**Date:** 03 May 2022

#### **PLANNING APPLICATION CONSULTATION RESPONSE**

<b>Application Number:</b>	3/2021/1262
<b>Proposal:</b>	Full application for the erection of 4no. commercial units (Use Class E).
<b>Location:</b>	Land at the North of the Chapel Hill site Longridge

PROPOSED SURFACE WATER DRAINAGE LAYOUT

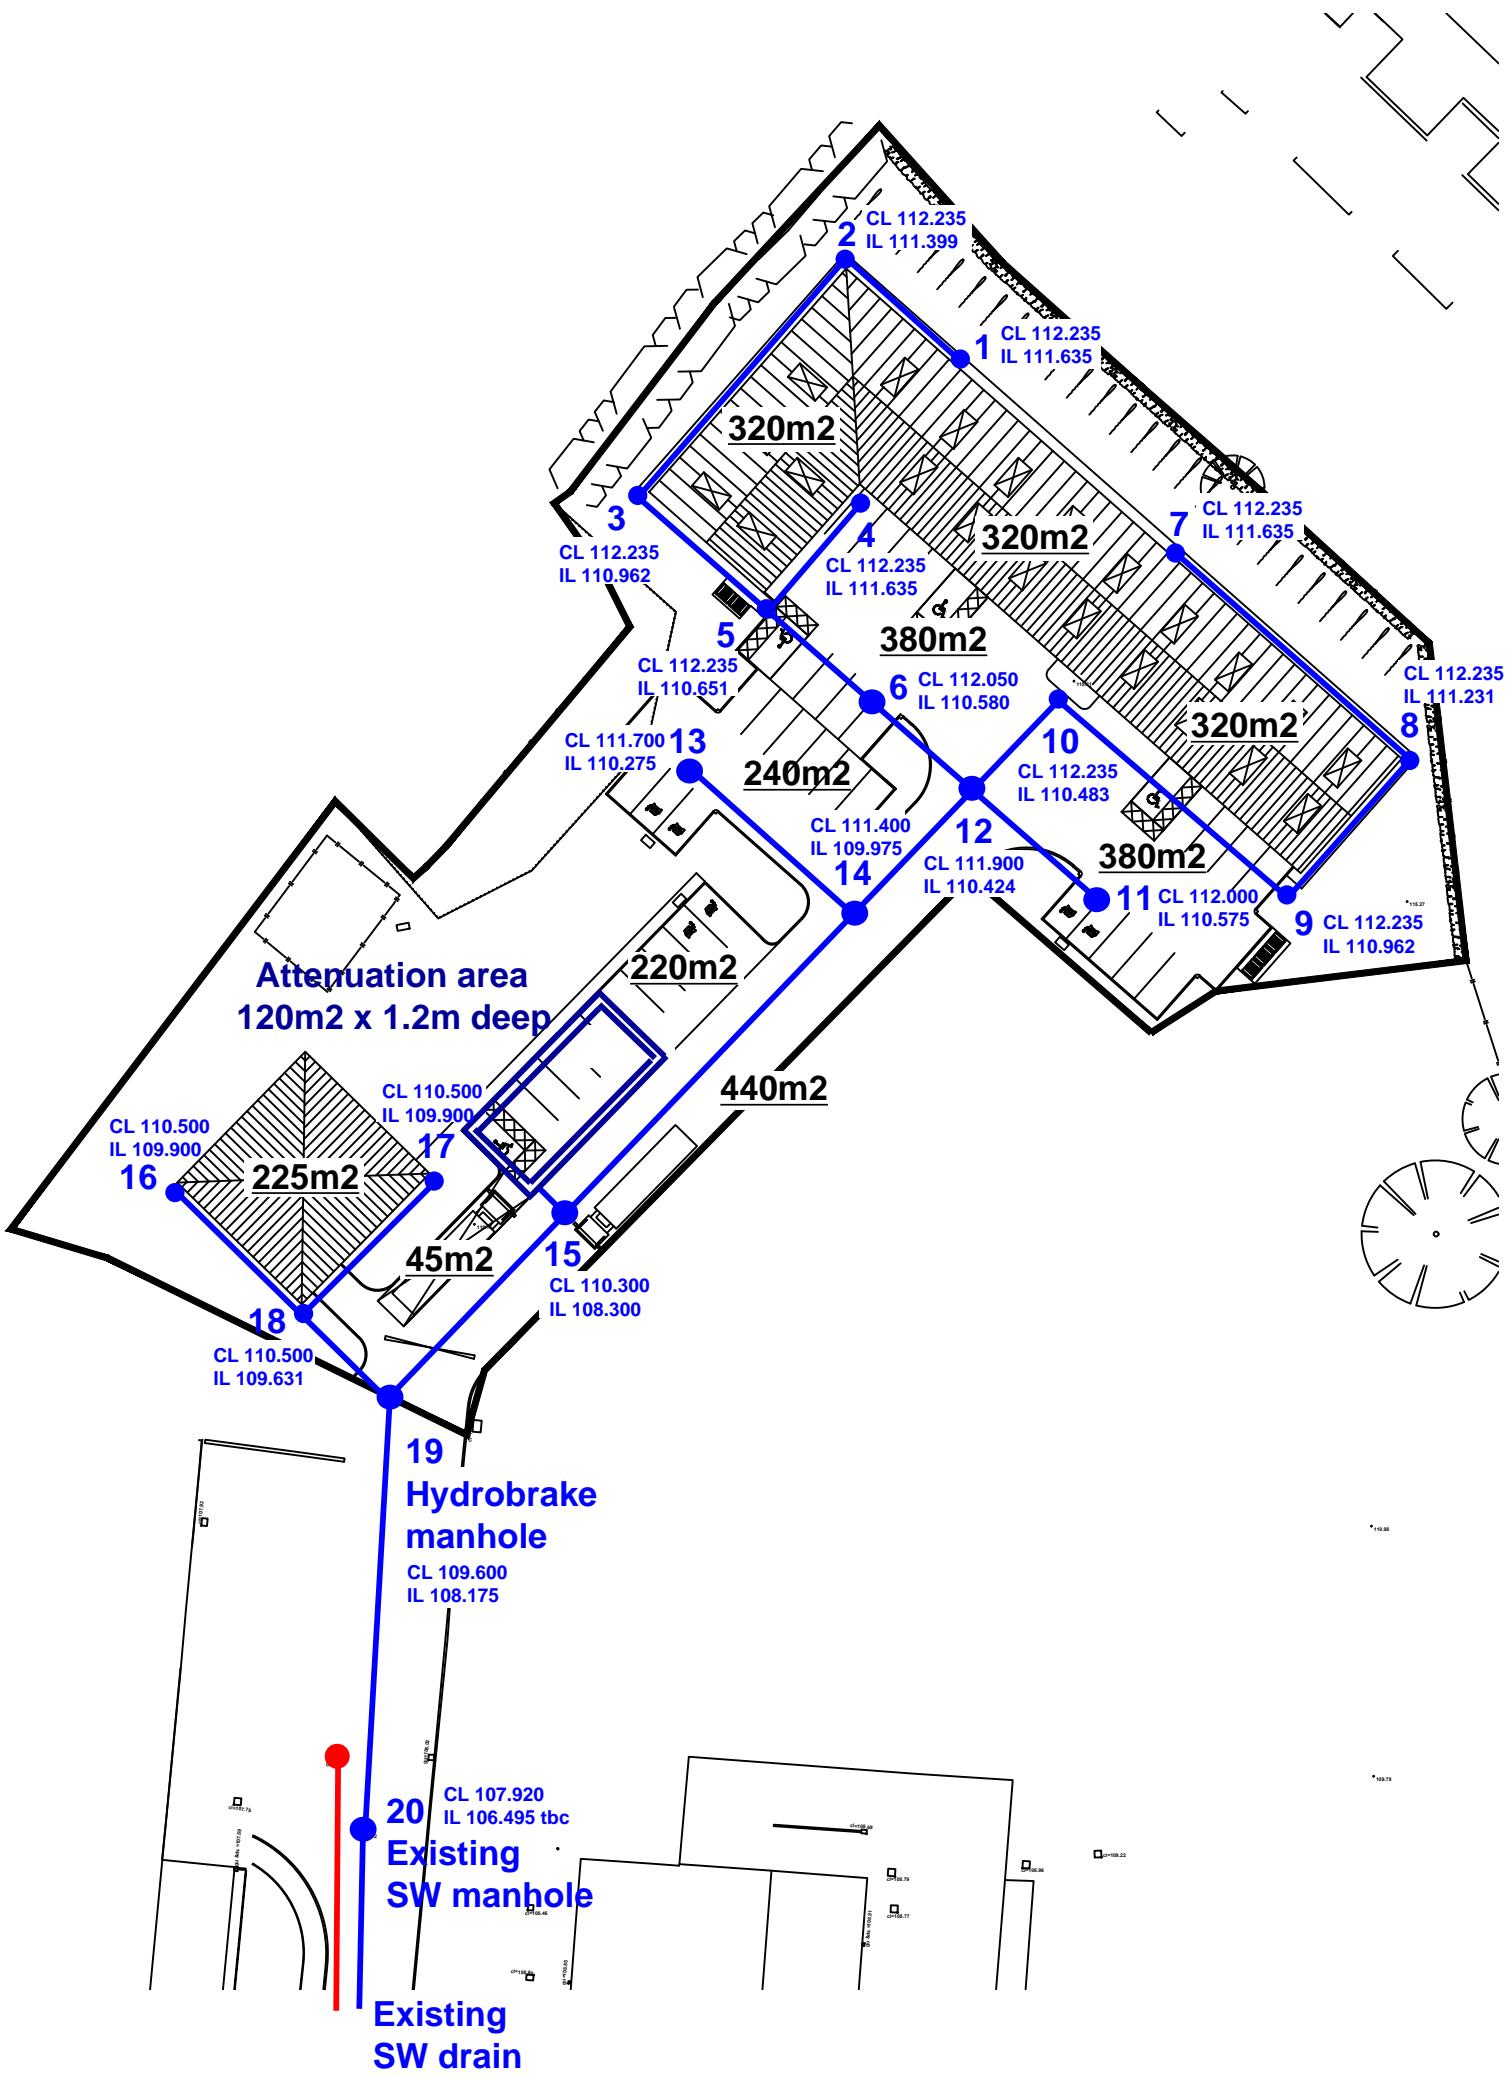
1. **Demonstrate the principle of development.** The proposed drainage strategy involves an on-site connection to the private surface water sewer, no evidence of an agreement in principle with the and asset owner has been provided to the Local Planning Authority. Should no agreement be reached, it may not be possible to drain the site, hence the Lead Local Flood Authority are currently unable to agree to the principle of development and recommend the refusal of planning permission, until evidence of an agreement in principle with the appropriate parties, or robust evidence of a 'plan b' outfall location, should a connection to the private surface water sewer not be possible, has been submitted to and approved in writing by the Local Planning Authority.

You can overcome our objection by submitting information that covers the deficiencies highlighted above and demonstrates how surface water will be managed on-site, to satisfy Paragraphs 167 and 169 of the National Planning Policy Framework, the Planning Practice Guidance, and the Defra Technical Standards for Sustainable Drainage Systems. If this cannot be achieved we are likely to maintain our objection to the application. Production of this information will not in itself result in the removal of an objection.
